Lead Local Flood Authority

Date 8th May 2026

RE: WA/18/26/PL - Land off Arundel Road Fontwell

This is a full application for the erection of 64 residential dwellings with access off Arundel Road, together with associated parking, open space, play space, landscaping, drainage and infrastructure.

Soakaway Test TP05

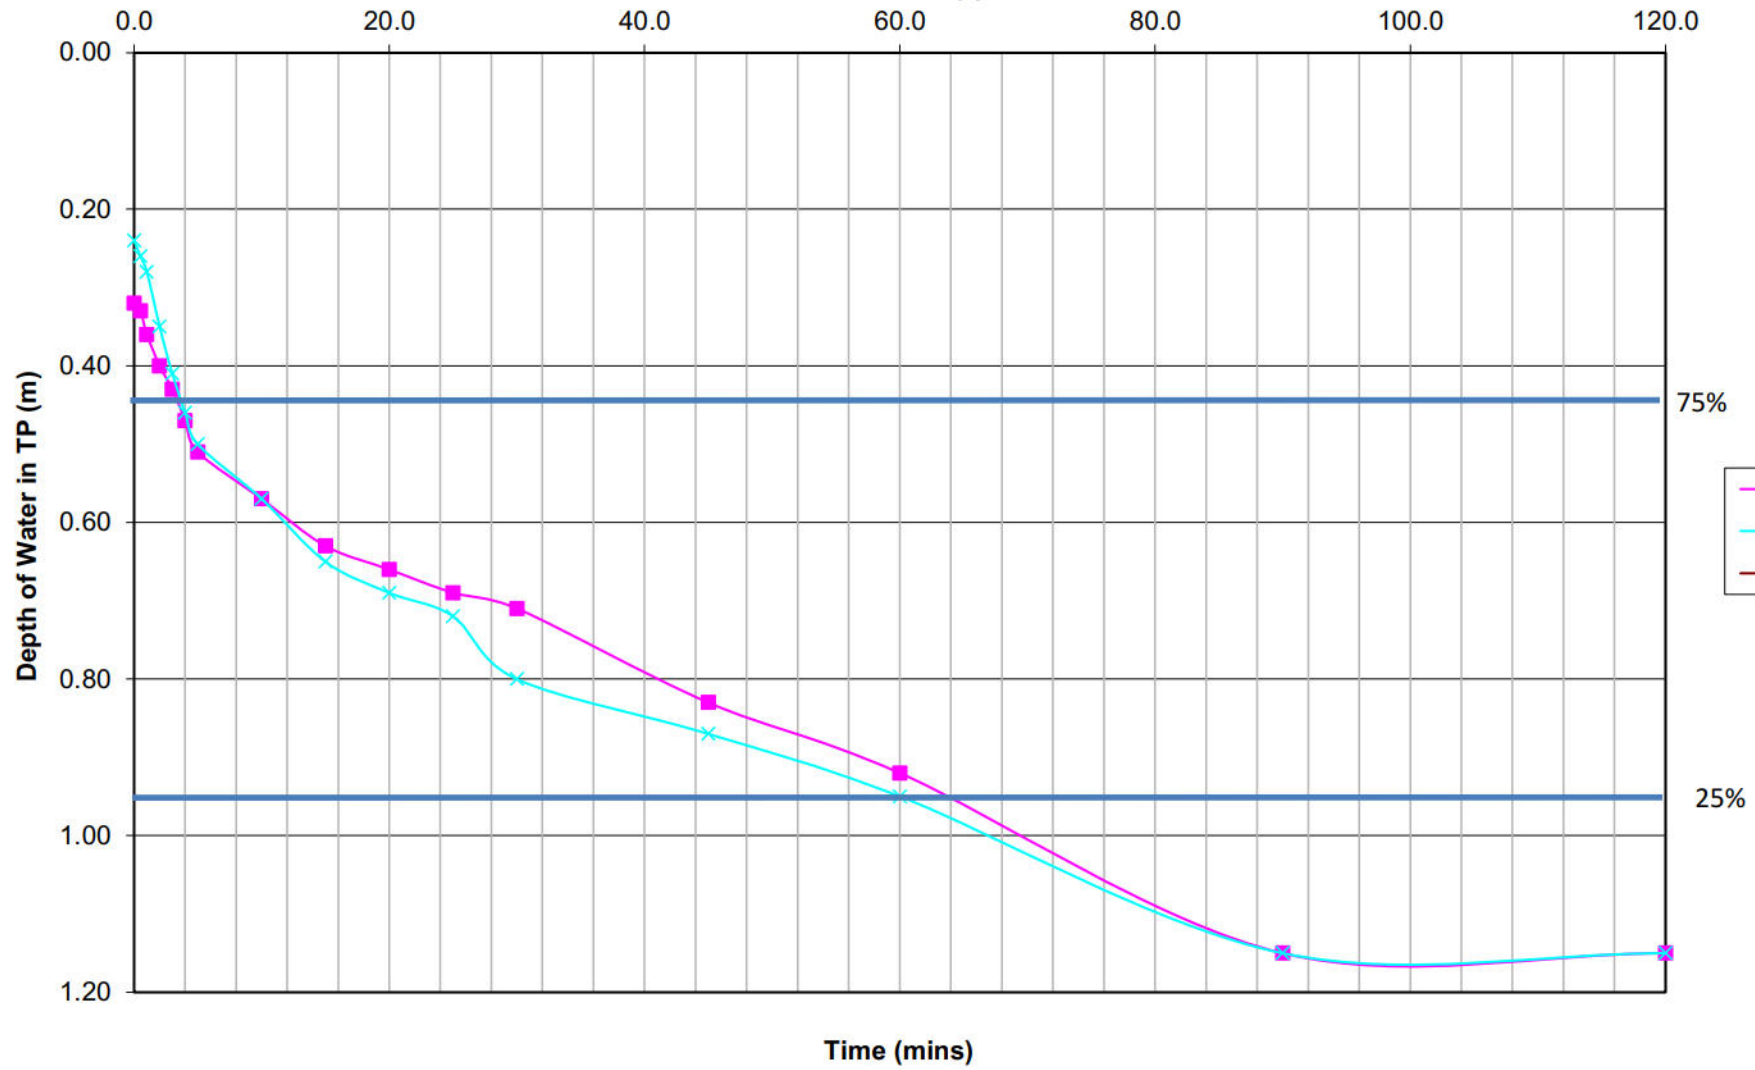
We are of the understanding that the highest recorded winter groundwater level is 1.4 mbgl in WS06 (although we do not appear to have the full winter results submitted under this application, we are relying on Table 2 in the FRA). For TP05, where the infiltration basin is proposed to be located, only 2 tests have been completed, which does not comply with BRE365 testing standards. The proposed base of the infiltration basin is 1.2 mbgl. This therefore means there is only 0.2m between the base of the infiltration basin and the highest groundwater level. This does not comply with the National Standards for SuDS, which state that a minimum of 1m clearance between the base of any infiltration feature and the highest level of groundwater. As this is a full planning application, this is not something we are able to condition, as the drainage strategy is likely to affect the layout of the site.

See point 2 – we are concerned that there is only 0.2m between the base of the infiltration basin and the highest groundwater level.

As previously requested, we therefore need a revised drainage strategy with an alternative method of draining the site.

Drainage Plans and Calculations

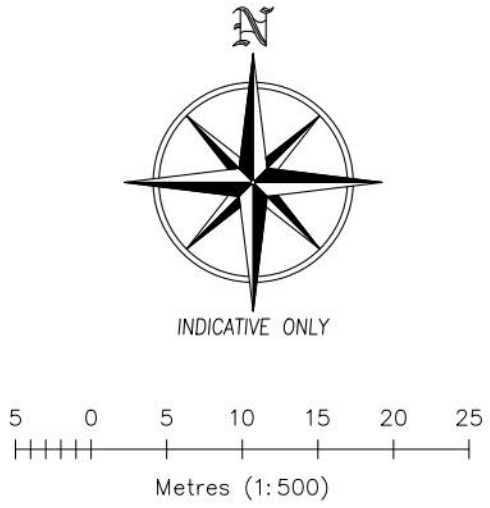
2. From the documentation provided, we have a significant concern that, due to high groundwater levels, the current design will not be viable. Section 1.15 of the above NSfS states that a minimum of 1m clearance between the base of any infiltration feature and the highest level of groundwater. Please confirm that this standard can be met, with appropriate evidence. Alternatively, please provide a revised drainage strategy incorporating an alternative method of surface water management. We understand this is likely to be utilisation of a WSCC Highway drain. If so evidence of approval for this should be appended (we note the current

4. We concur with the proposal to line some of the proposed permeable paving due to groundwater levels, however should there be any areas within the site that have the opportunity to utilise unlined attenuation, this should be explored.
